# **Awel y Môr Offshore Wind Farm**

## **Applicant's Response to Written Representations**

### **Deadline 2**

**Date: 09 November 2022**

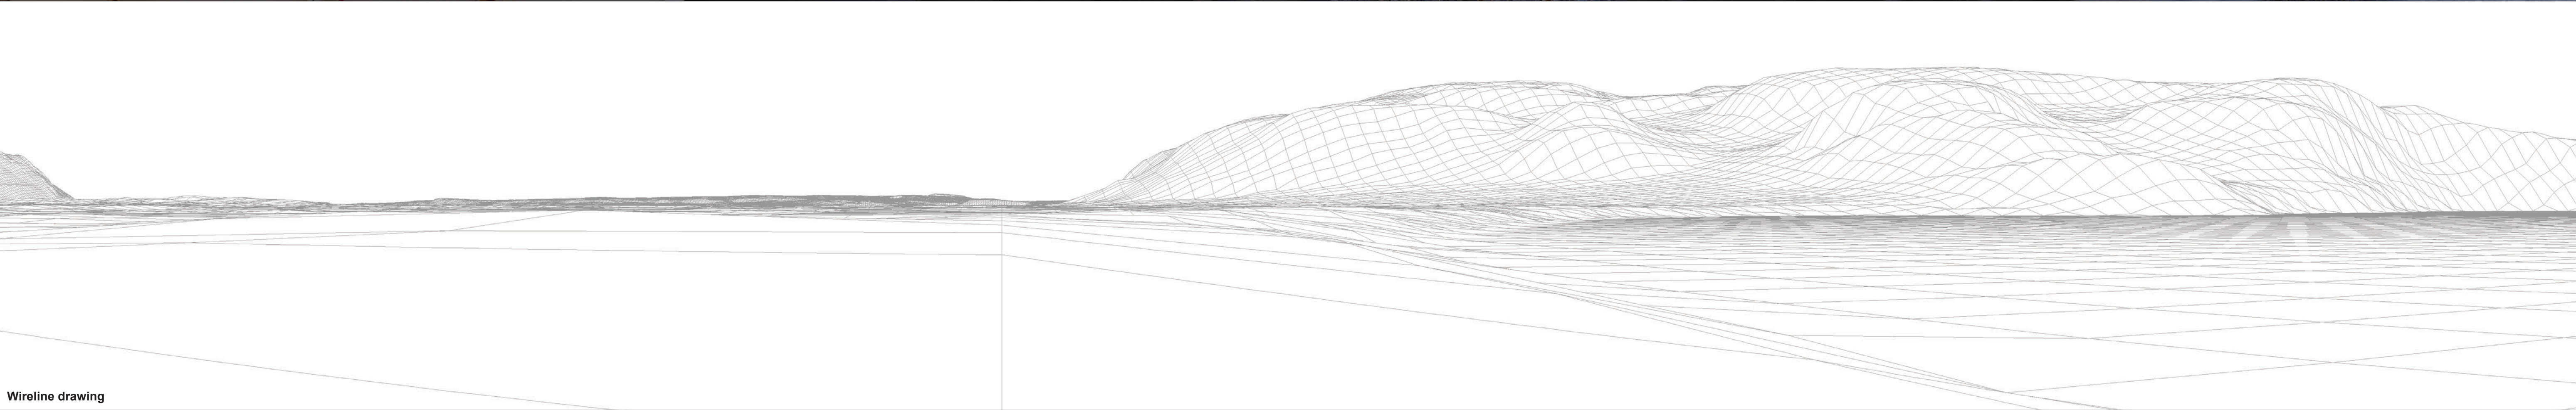
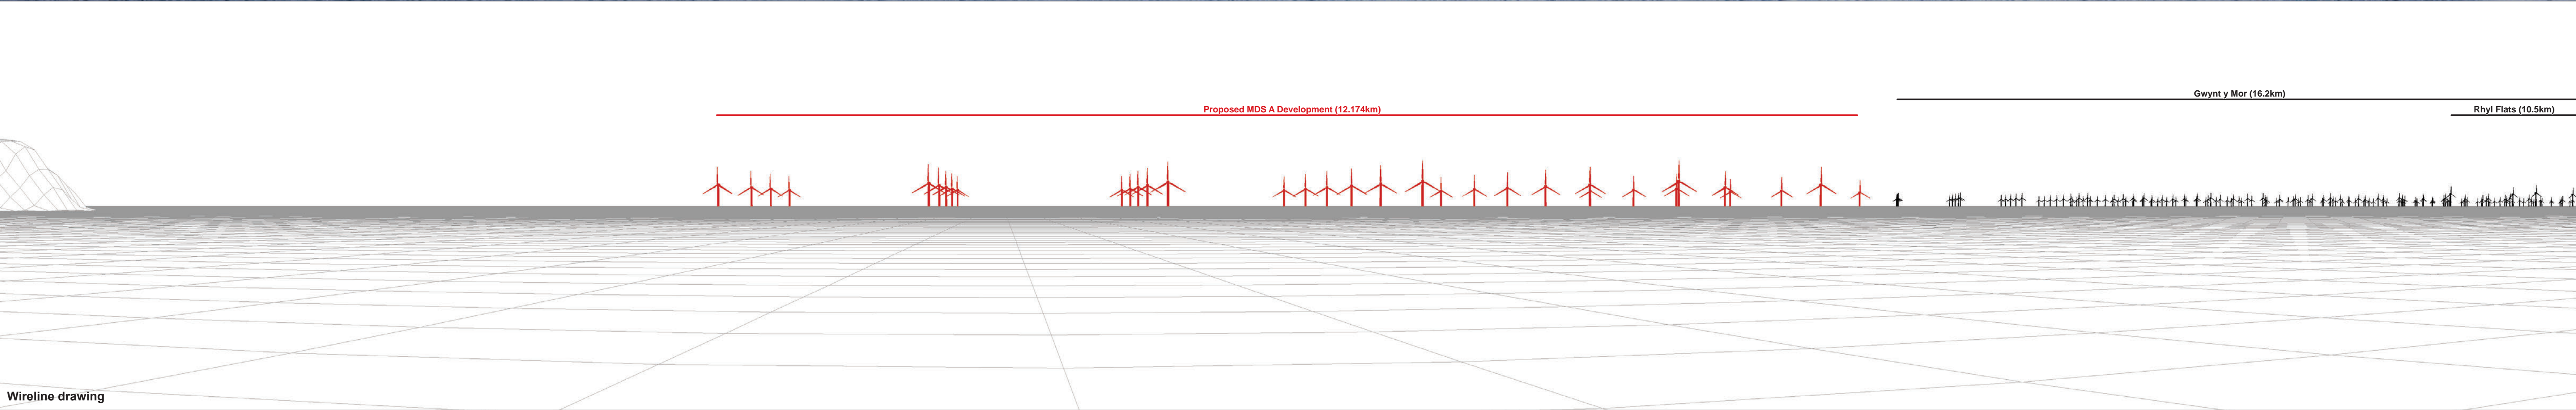
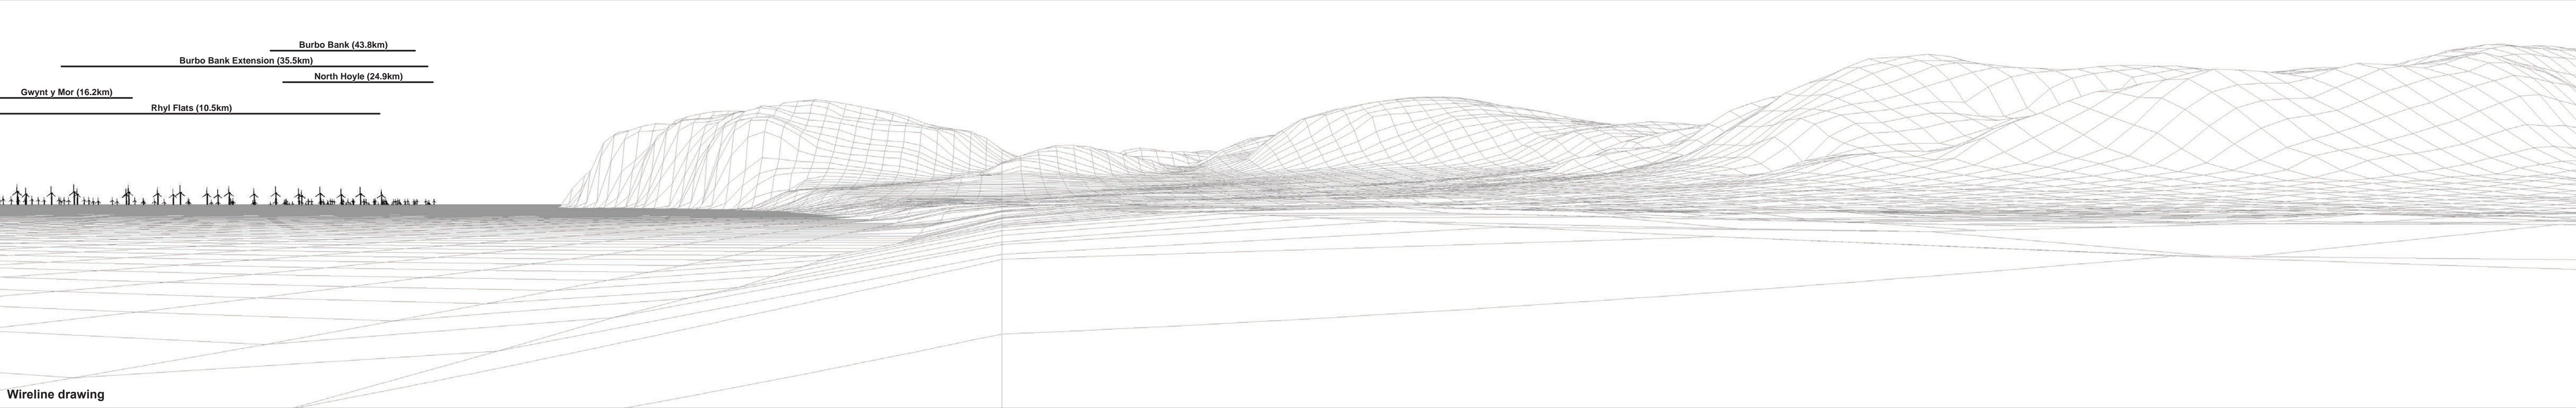
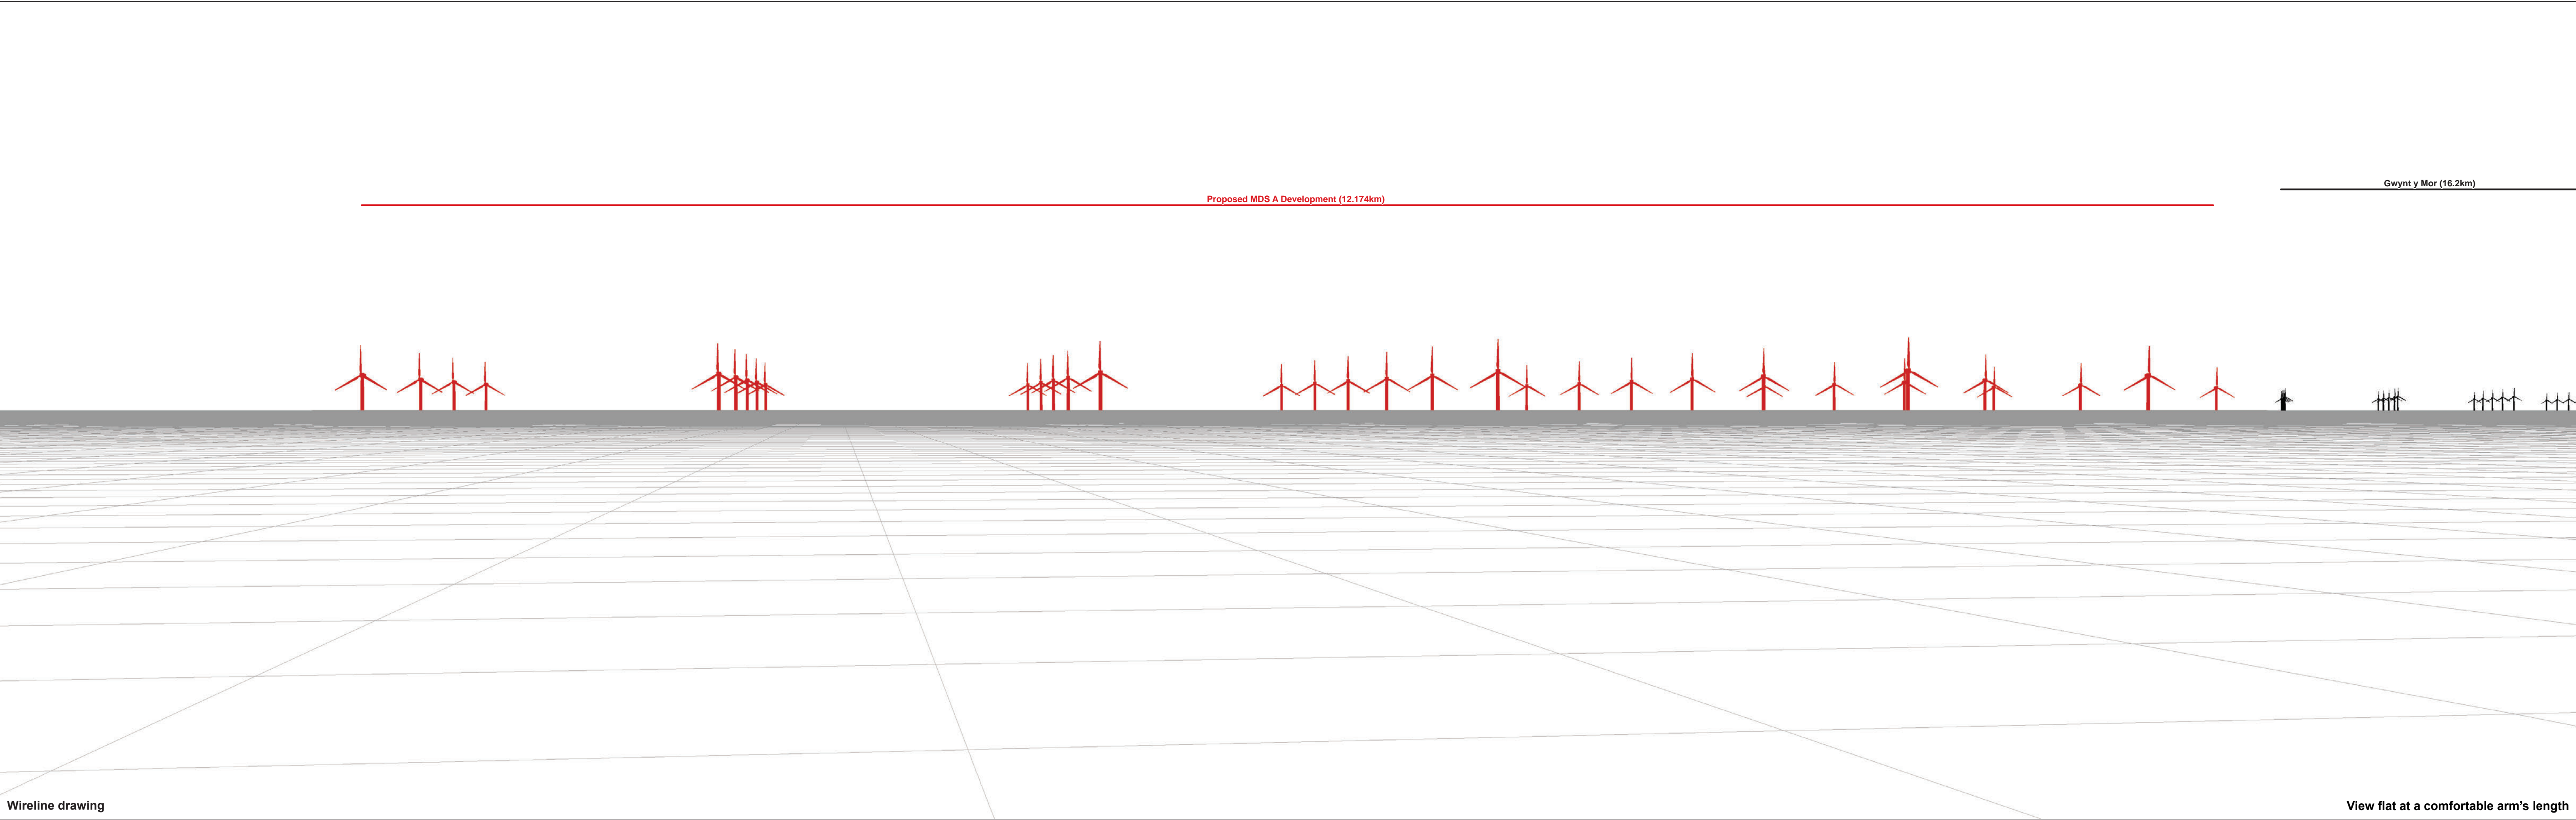
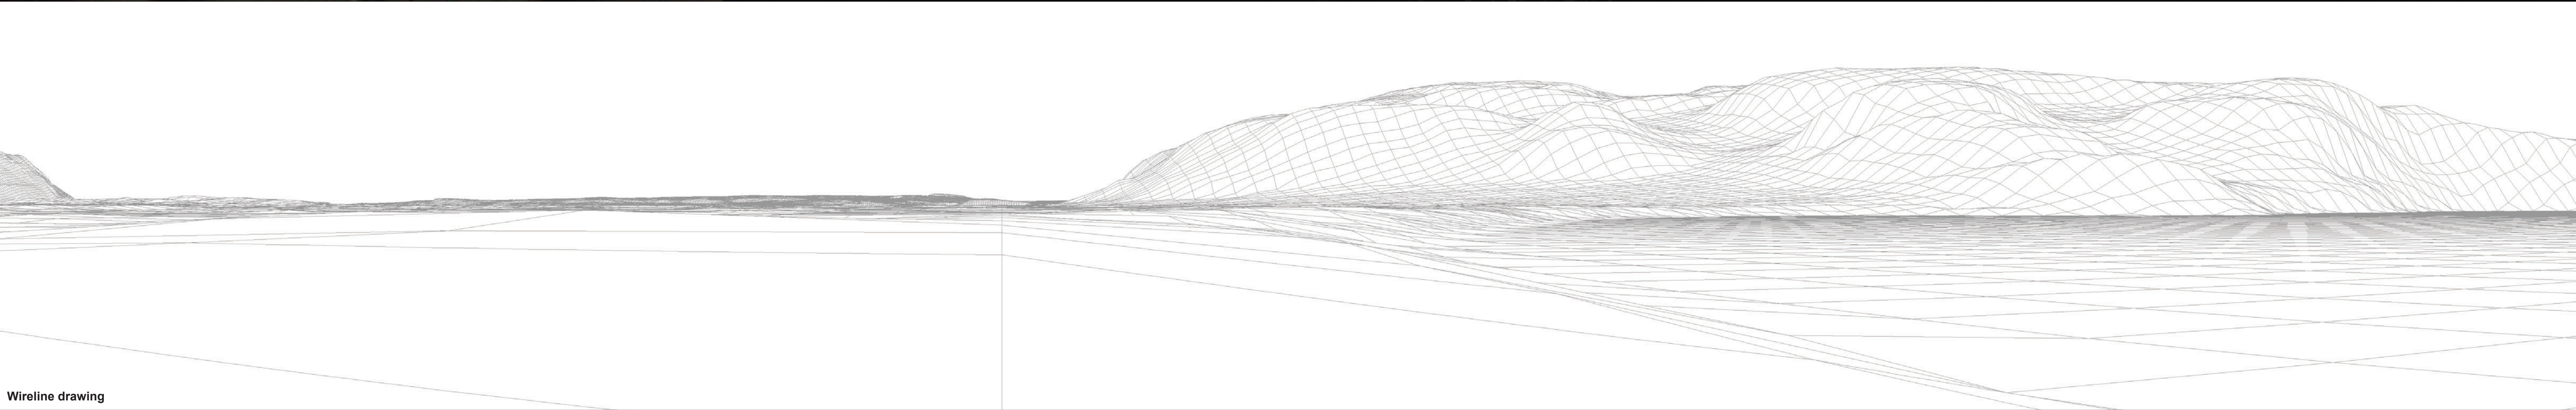
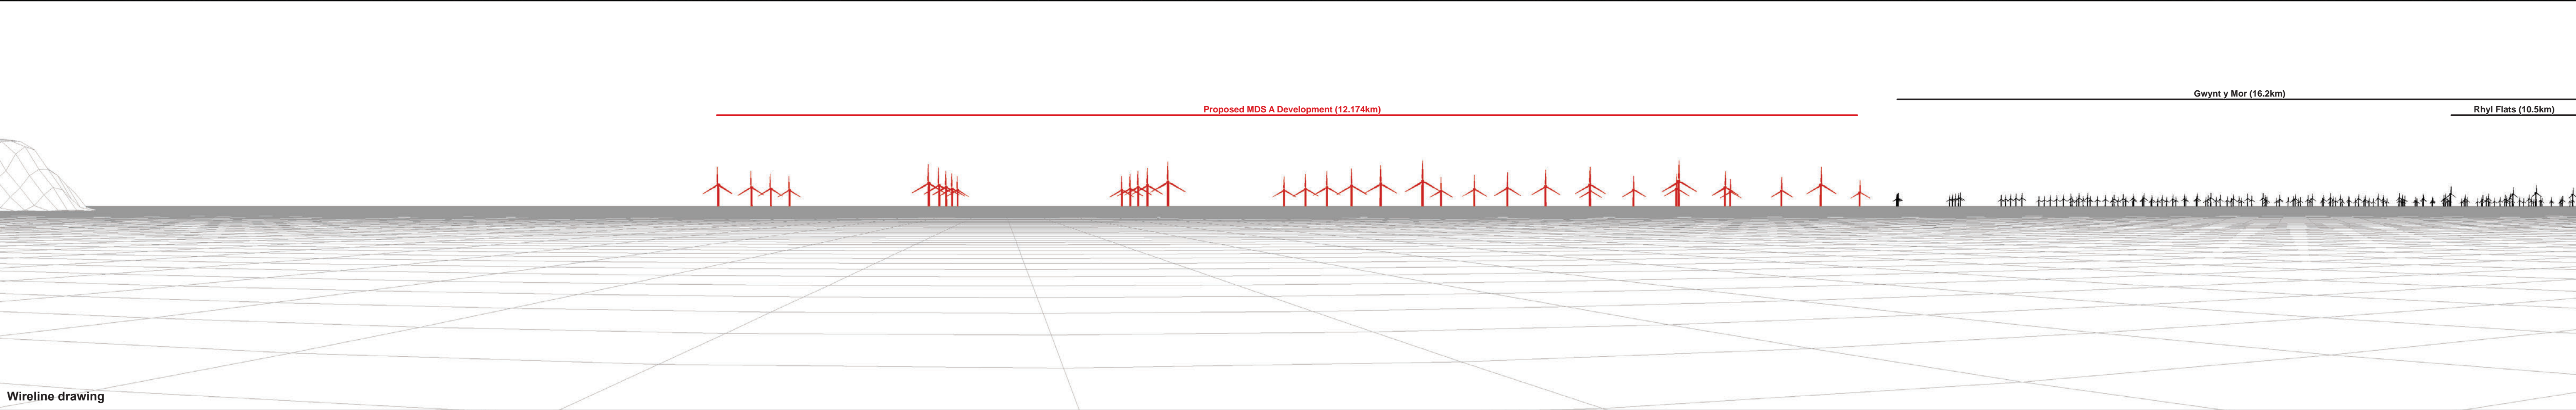
REP1-055-4.15	<p>The impact of the AMOWF on the setting of views towards, and from, the Great Orme and Little Orme is illustrated in particular in the following images in the SLVIA:</p> <ul style="list-style-type: none"> <li>▲ Figures 38c, 38d and 38e: Llanfairfechan (22.353km)</li> <li>▲ Figure 39b: Conwy Mountain (17.3km)</li> <li>▲ Figures 40c, 40d and 40e: Great Orme summit (11.89km)</li> <li>▲ Figures 42c, 42d and 42e: Great Orme café (11.294km)</li> <li>▲ Figures 45c, 45d, and 45e: Llandudno paddling pool (11.878km)</li> <li>▲ Figures 46b and 46c: Rhos-on-Sea (12.424km)</li> <li>▲ Figure 47c: Bryn Euryn (13.428km)</li> <li>▲ Figure 48b: Mynydd Marian (16.246km)</li> <li>▲ Figure 64b: Cefn Coch stone circle (23.895km)</li> <li>▲ Figure 67c: Above Capelulo (19.13km)</li> <li>▲ Figure 75c: Pen Dinas (11.792km)</li> <li>▲ Figure 78b: Footpath above Cilgwyn Mawr (16.936km)</li> <li>▲ Figure 81c: Little Orme (11.258km)</li> <li>▲ Figure 82b, 82c and 82e Llandudno promenade – lifeboat slipway (12.051km)</li> <li>▲ Figure 83c, 83d and 83f: Foel Lus (19.599km)</li> <li>▲ Figure 84c and 84h: Llandudno Promenade near Venue Cymru (12.174km)</li> </ul>
